# Rezoning Transportation Analysis

Petition Number: 2022-155

## Revision Log:

Date	Description
1-25-23	First Review (TM)
2-23-23	Second Review (TM)
03-30-23	Third Review (TM)

RZ.01

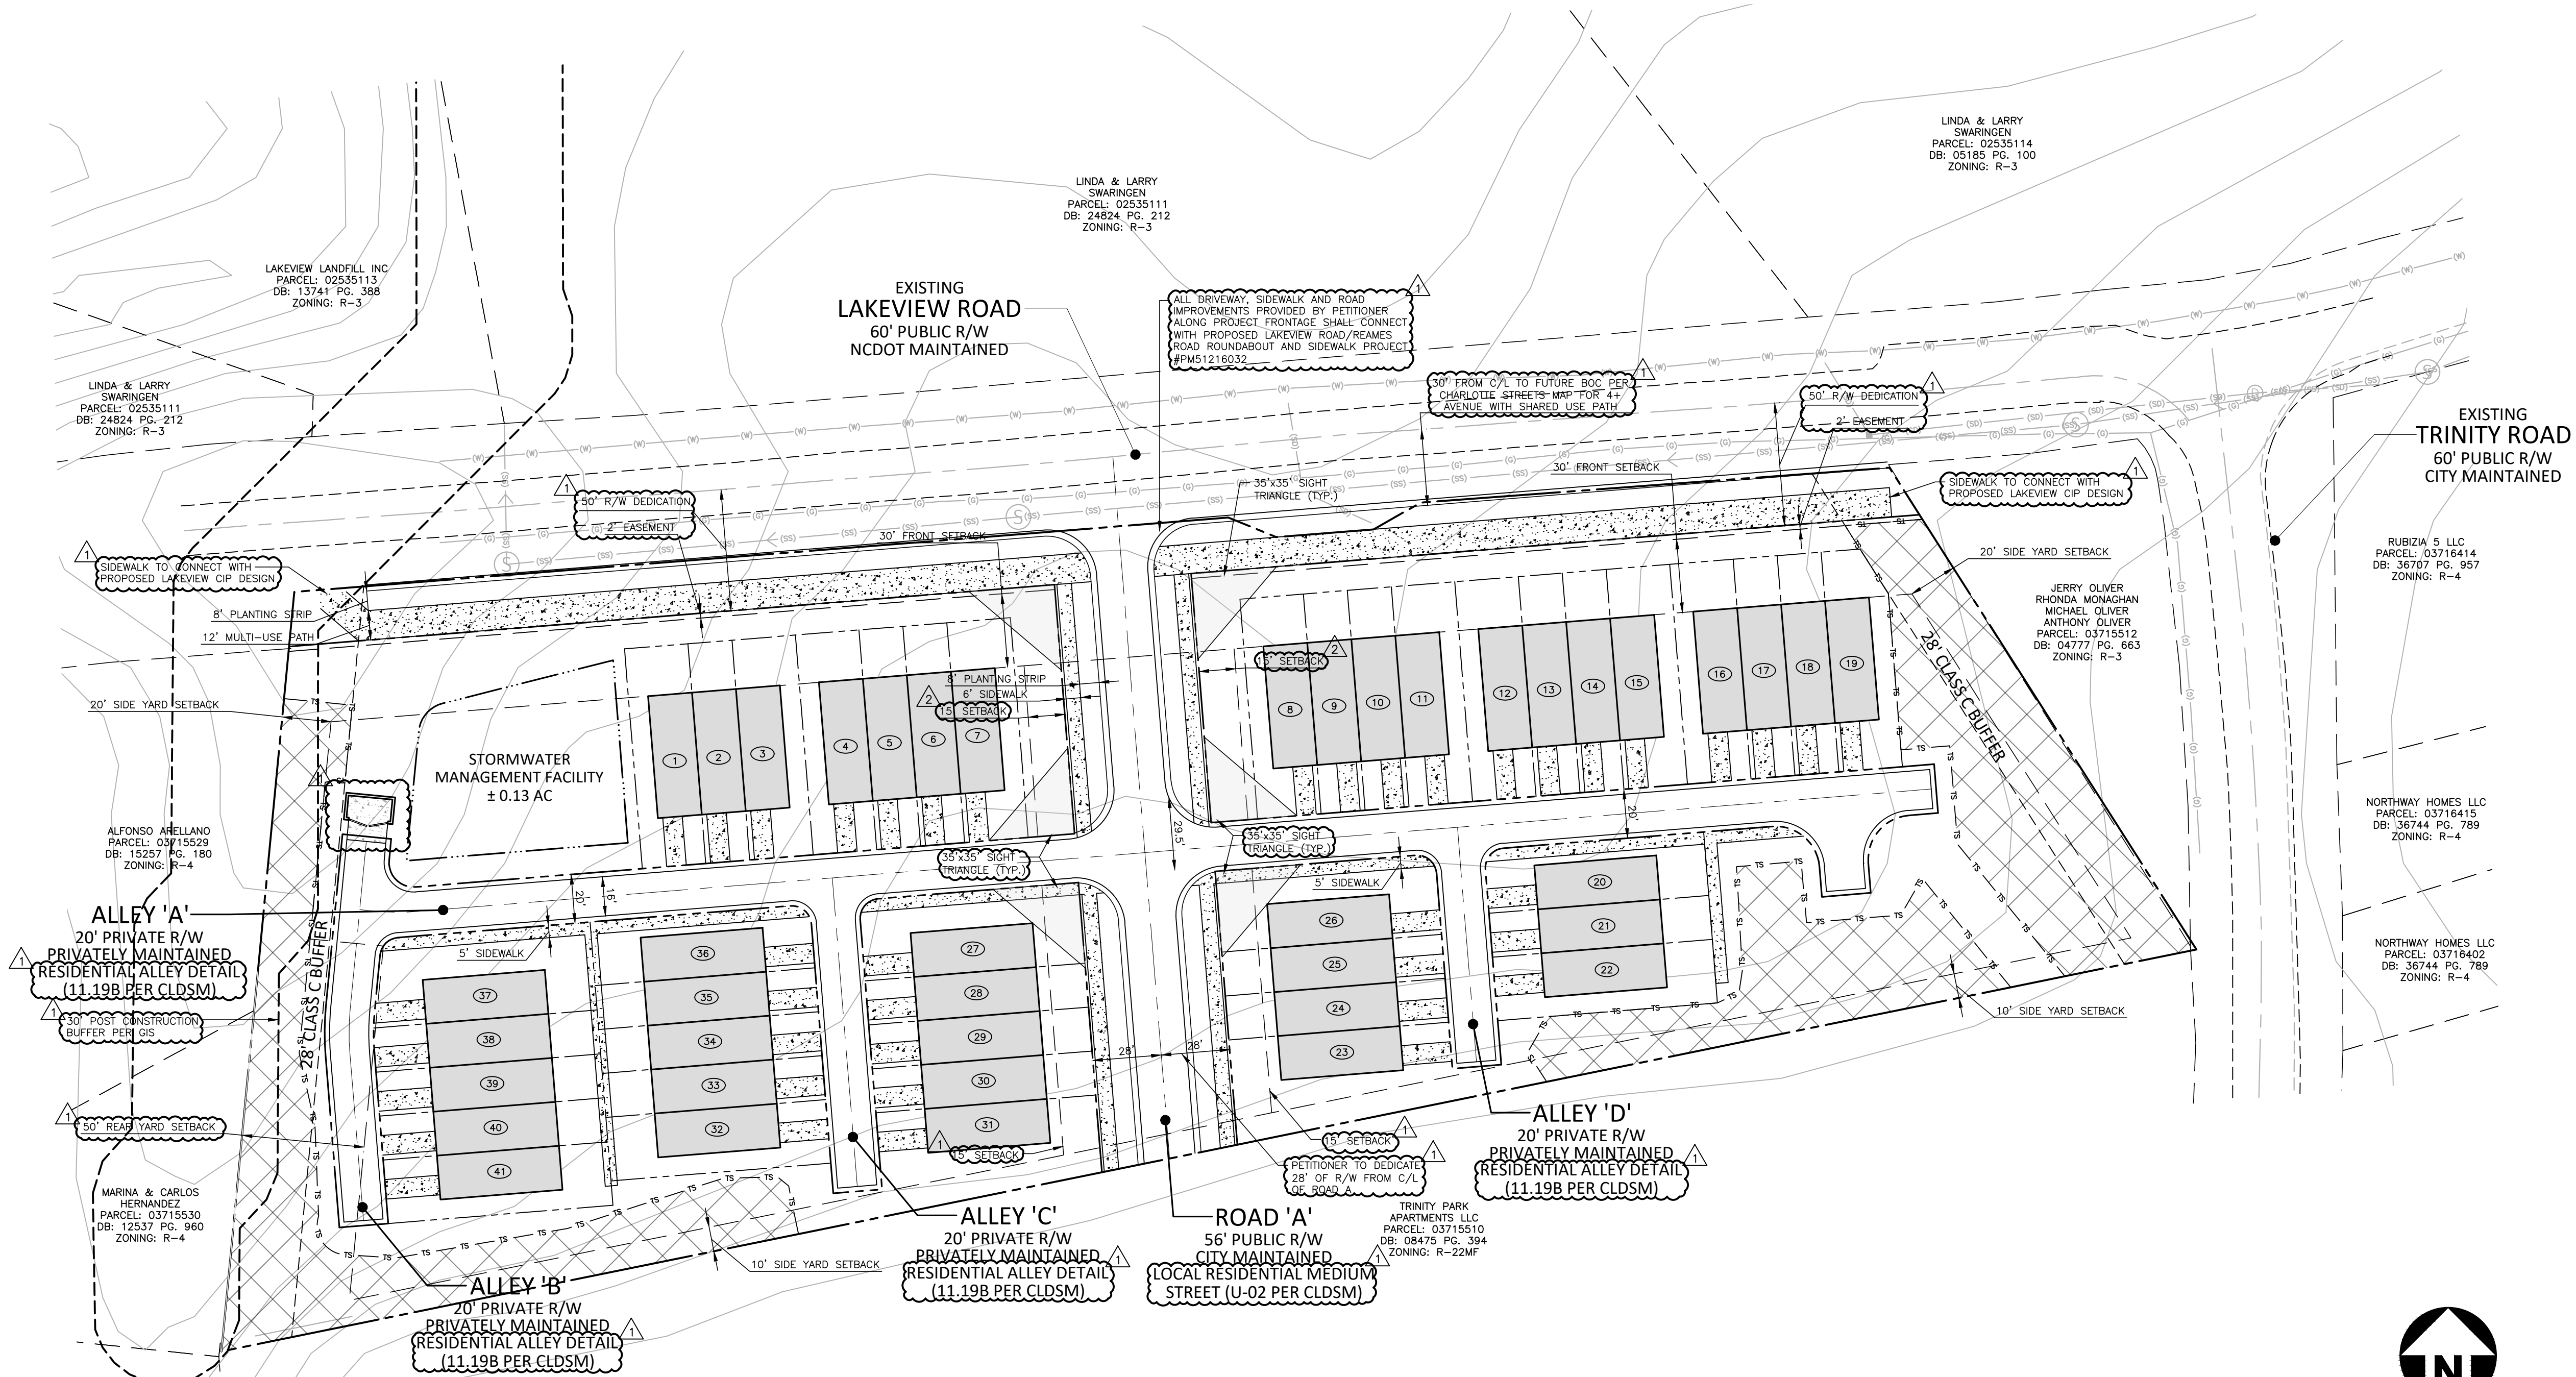
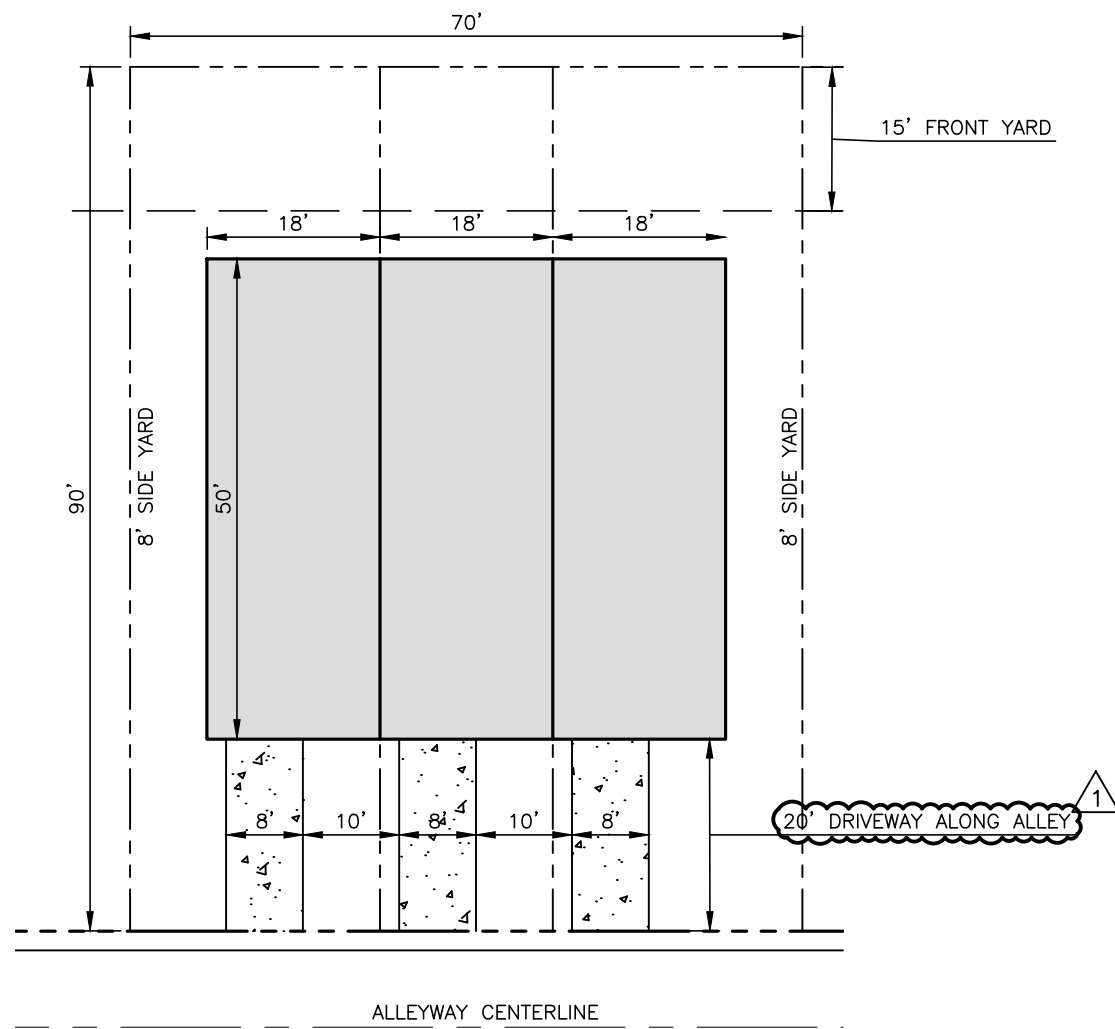
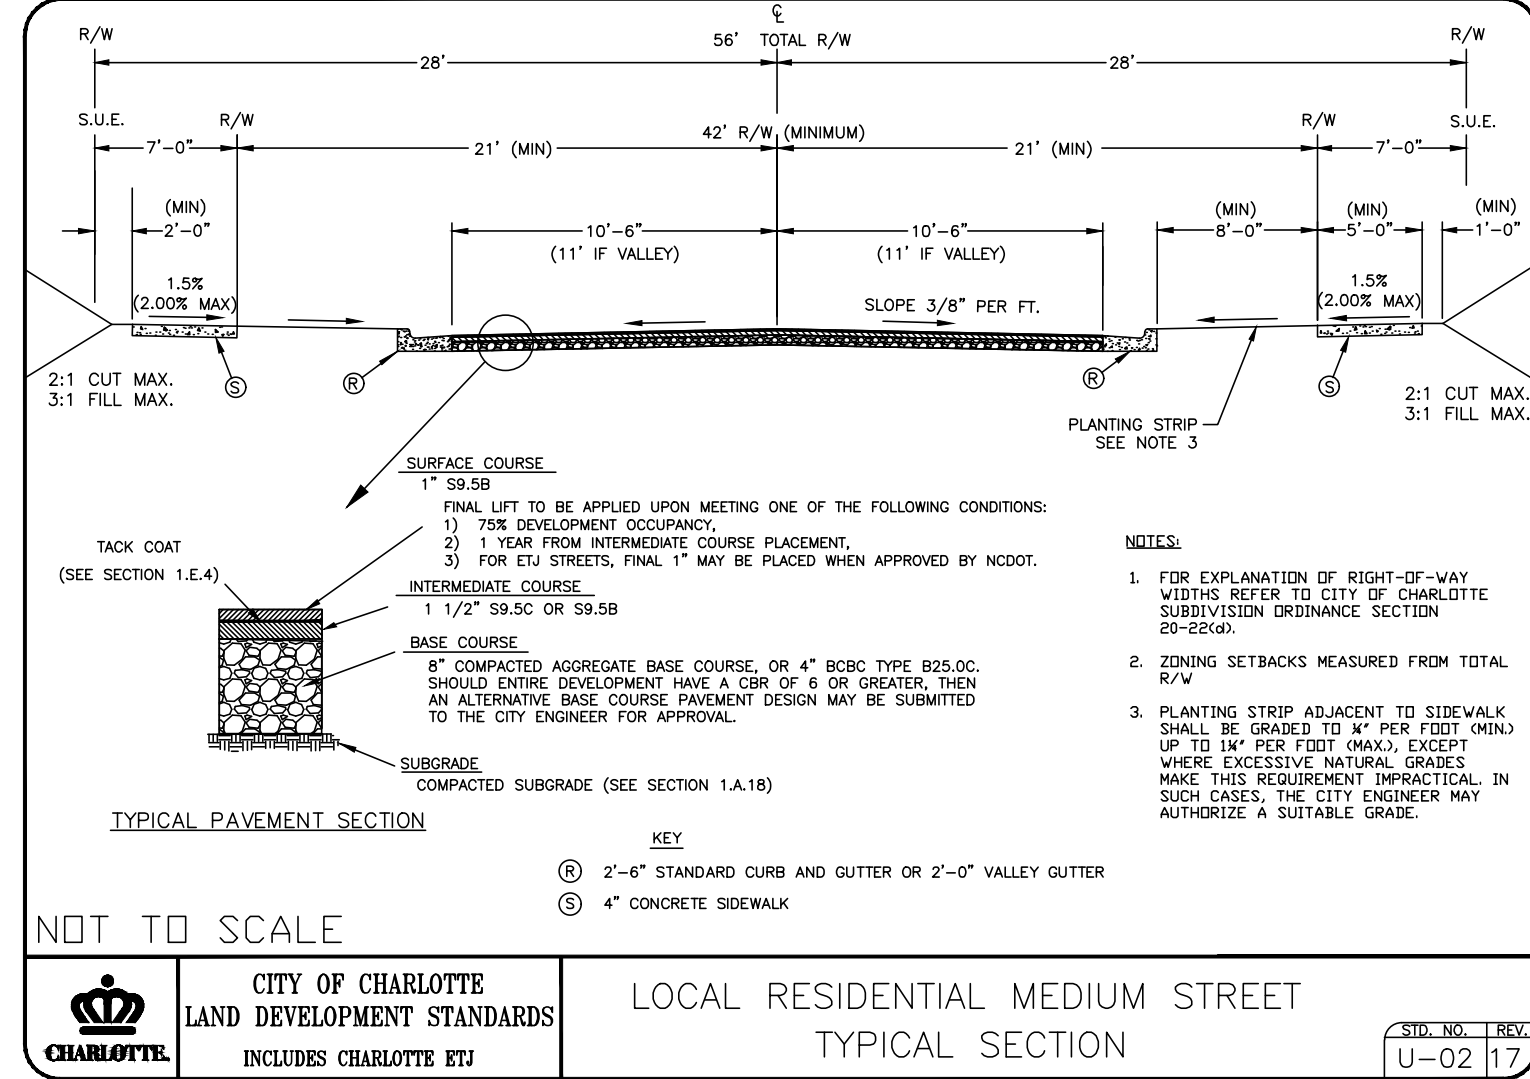
- a. ~~Lakeview Road:~~ Location of future curb and gutter to be moved to 30 feet from roadway centerline to accommodate the Charlotte Streets Map with a future roadway typical section of a 4+ Avenue (including a two-way left turn lane) and Shared Use Path.

~~Label and dimension the curb and gutter from the centerline for each road on the site plan.~~

3. ~~Revise site plan and conditional note(s) to commit to dedicate 28 feet of right of way from the road centerline of Roadway A. The site plan shall label and dimension the right of way from the road centerline.~~

4. ~~Revise site plan and conditional note(s) to commit to construct an 8-foot planting strip, and 6-foot sidewalk on Road A per Chapter 19. The site plan shall label and dimension both items from the back of curb and gutter or edge of pavement.~~

6. ~~Revise site plan and conditional note(s) to commit to completing a developer agreement with the active CIP project prior to permitting approval. Revise site plan to show the updated easement information and CIP project linework including streetscape and ROW that has been previously purchased.~~

7. ~~Revise site plan and conditional note(s) to commit to extending road A and roadway infrastructure (curb line and sidewalk) to the property line.~~

8. ~~Revise site plan and conditional note(s) to commit to clearly identifying Road A as standard from the CLDSM. Add standard to the callout of road A as well as add a conditional note committing to constructing roadway A to a CLDSM standard. Site plan shall label and dimension roadway infrastructure from the roadway centerline including ROW.~~
9. ~~Revise site plan and conditional note(s) to commit to clearly identifying Alley cross sections as a standard from the CLDSM. Add standard to the callout of alleyways as well as add a conditional note committing to constructing them to CLDSM standard.~~
10. ~~Revise site plan by dimensioning the sidewalk along Alley A.~~
11. ~~Revise site plan by adding CDOT sight triangles to the intersection of Alley A and Roadway A per CDOT sight distance policy. Show either the 50 x 50 sight triangle or the 35 x 3 sight triangle.~~

## **~~15. CDOT NOTE 02-22-23: Driveways will be required to be moved out of sight triangles.~~**
